From: Hornby, Mark [Mark.Hornby@lancashire.gov.uk]
Sent: 10 October 2012 13:18
To: Graeme Thorpe
Cc: Mark Wilkinson
Subject: FW: Consultation on planning application 3/2012/0745 Brown Leaves Hotel, Longsight Road, Copster Green

I have had several discussions with Mark Wilkinson of McDermott Homes regarding the details of the highway layout and am happy with the submitted plans from a highway perspective.

Please can we have your comments on the above proposal? It is a reserved matters application (following outline approval 3/2011/0482) for the appearance, landscaping, layout and scale of 18 dwellings and associated works. I have attached the formal consultation letter but there are too many plans to attach to an email so here is a link to view the application on our website
<http://www.ribblevalley.gov.uk/planningApplication?appNumber=3%2F2012%2F0745&submit=Go>

Scale 1:250
Rev	Date	Revision	Date May 2012
Title			Dwg. No.
SITE LAYOUT			PL.02

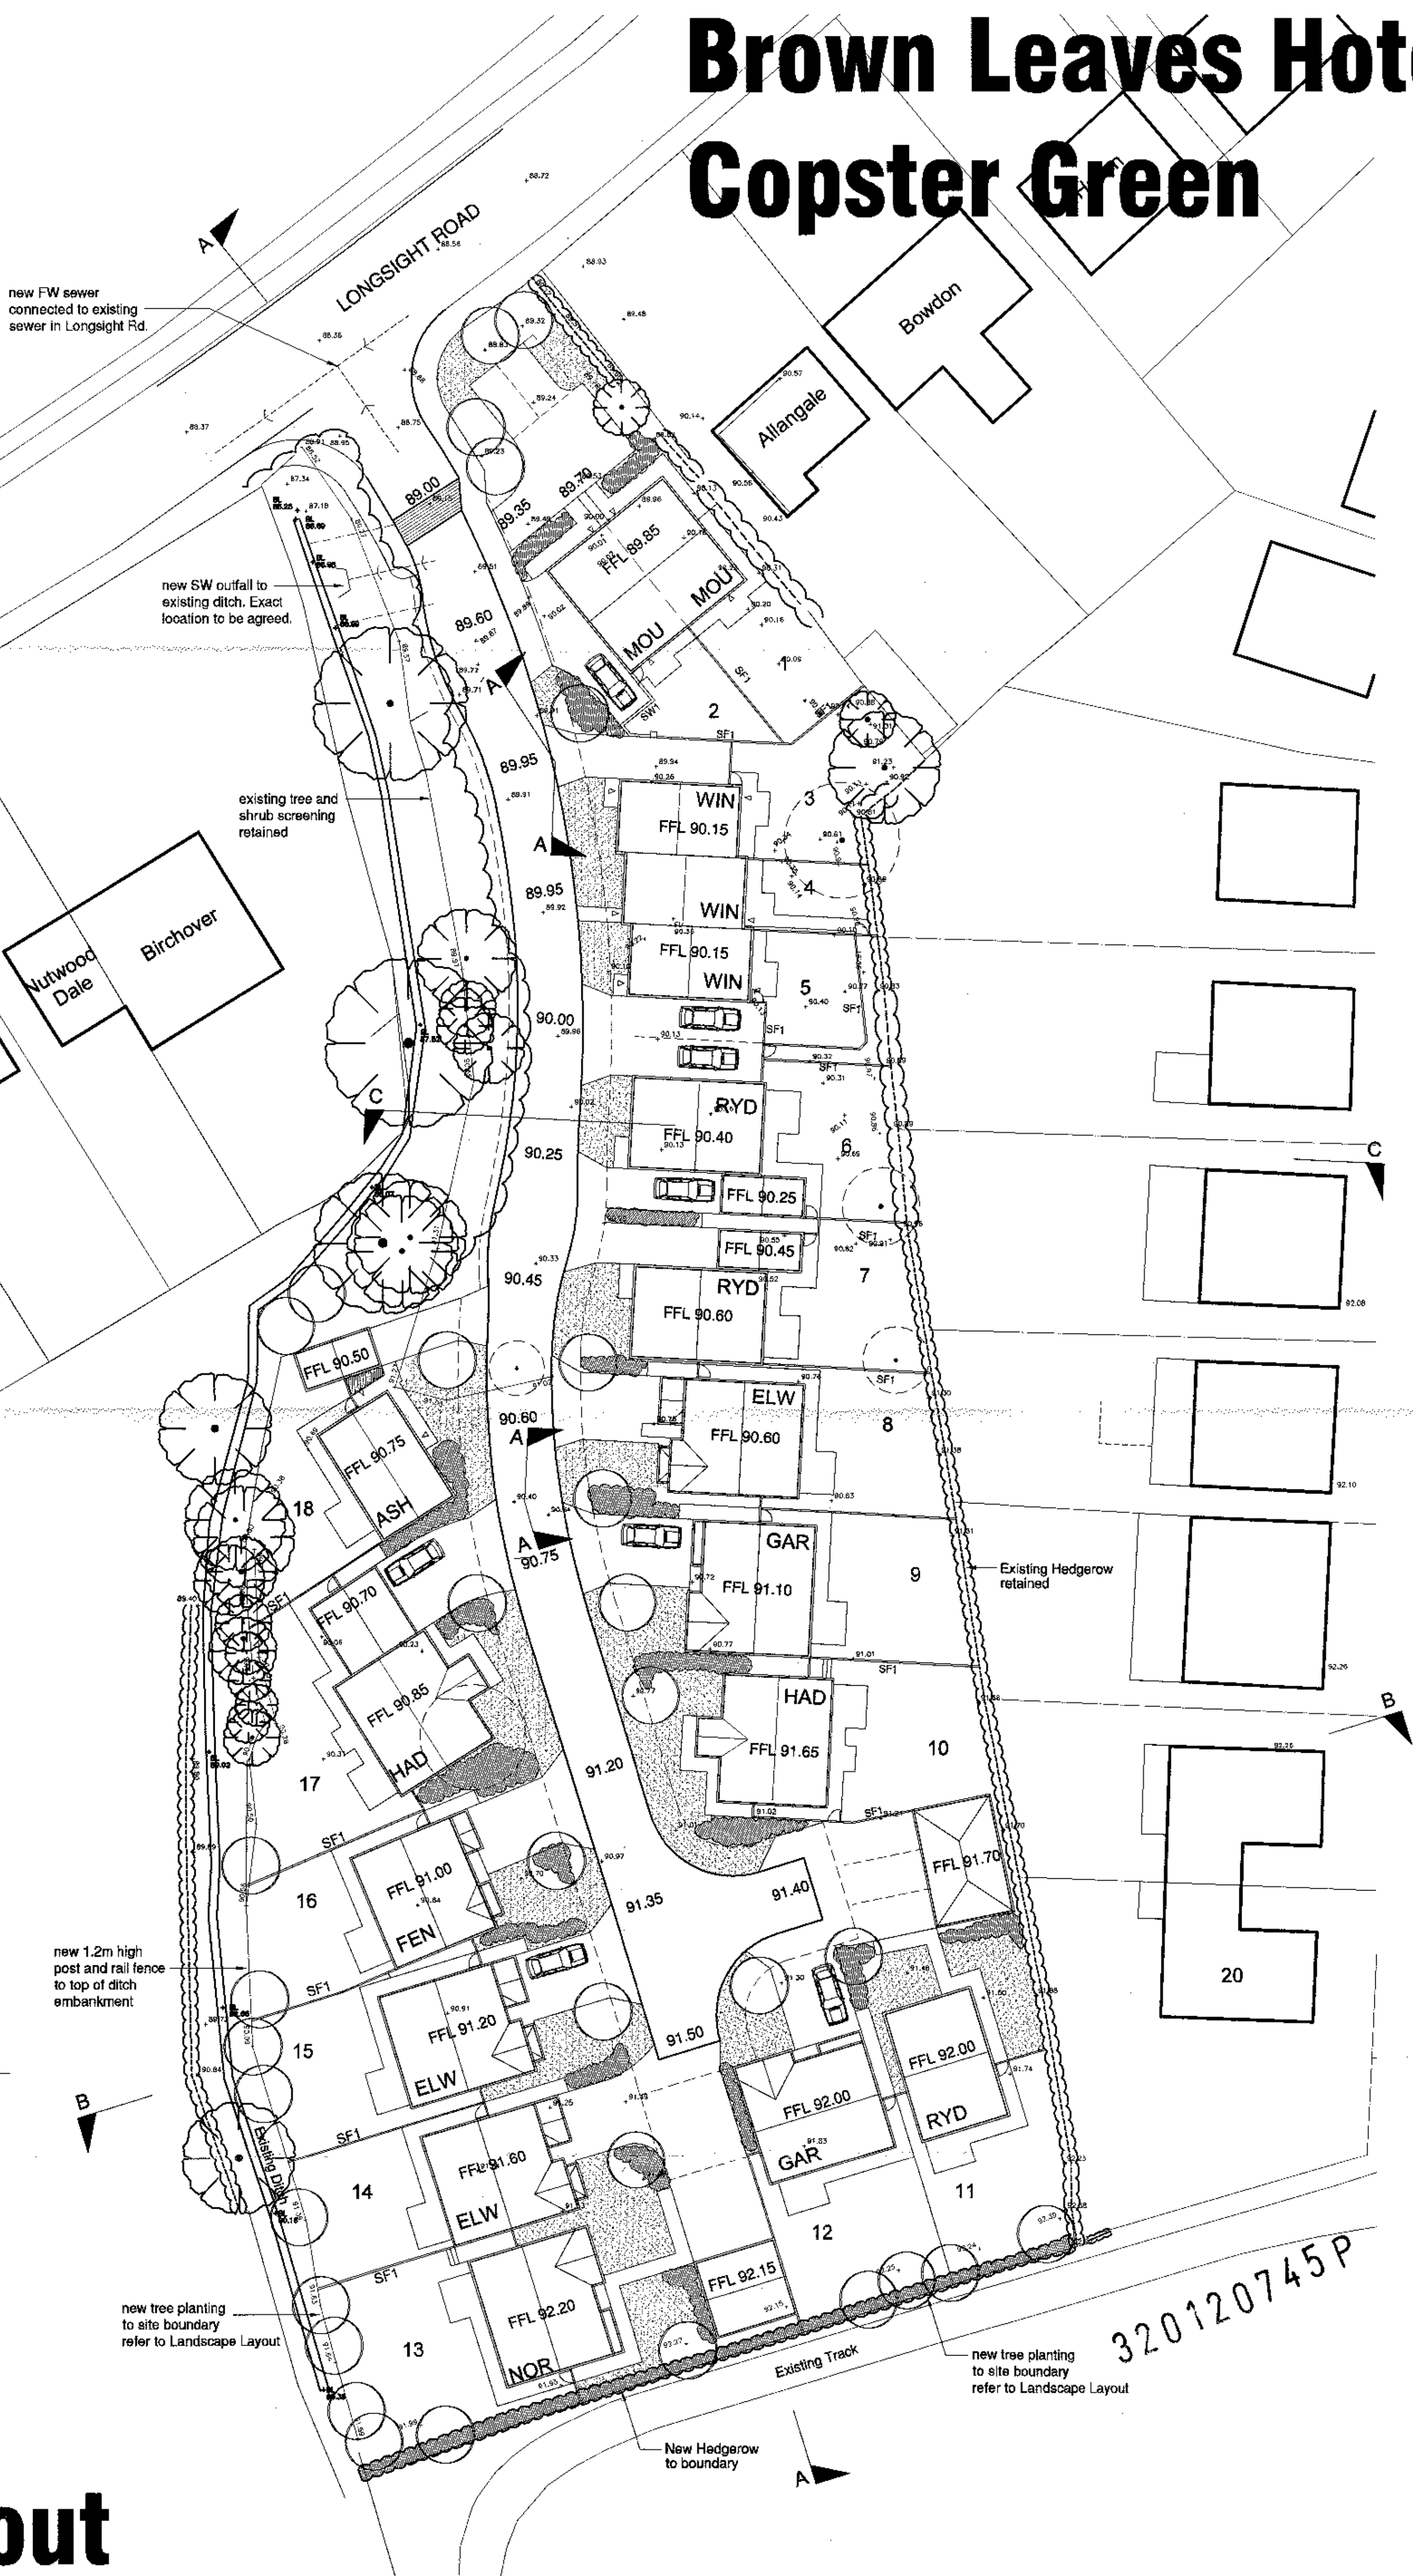
2. The existing Clayton-le-Dale boundary sign adjacent to the proposed access road shall be removed and relocated to a suitable alternative position at the developers expense. Reason: To ensure adequate visibility at the site access.

3. The proposed access road from the site to the A59 Longsight Road shall be constructed to a width of 5.5 metres and this width shall be maintained for a minimum distance of 10 metres measured back from the nearside edge of the carriageway of the A59 Longsight Road. Reason: To enable vehicles to enter and leave the site in a safe manner without causing a hazard to other road users.

4. The new estate road/access between the site and the A59 Longsight Road shall be constructed in accordance with the Lancashire County Council Specification for Construction of Estate Roads to at least base course level before any development takes place within the site. Reason: To ensure that satisfactory access is provided to the site.
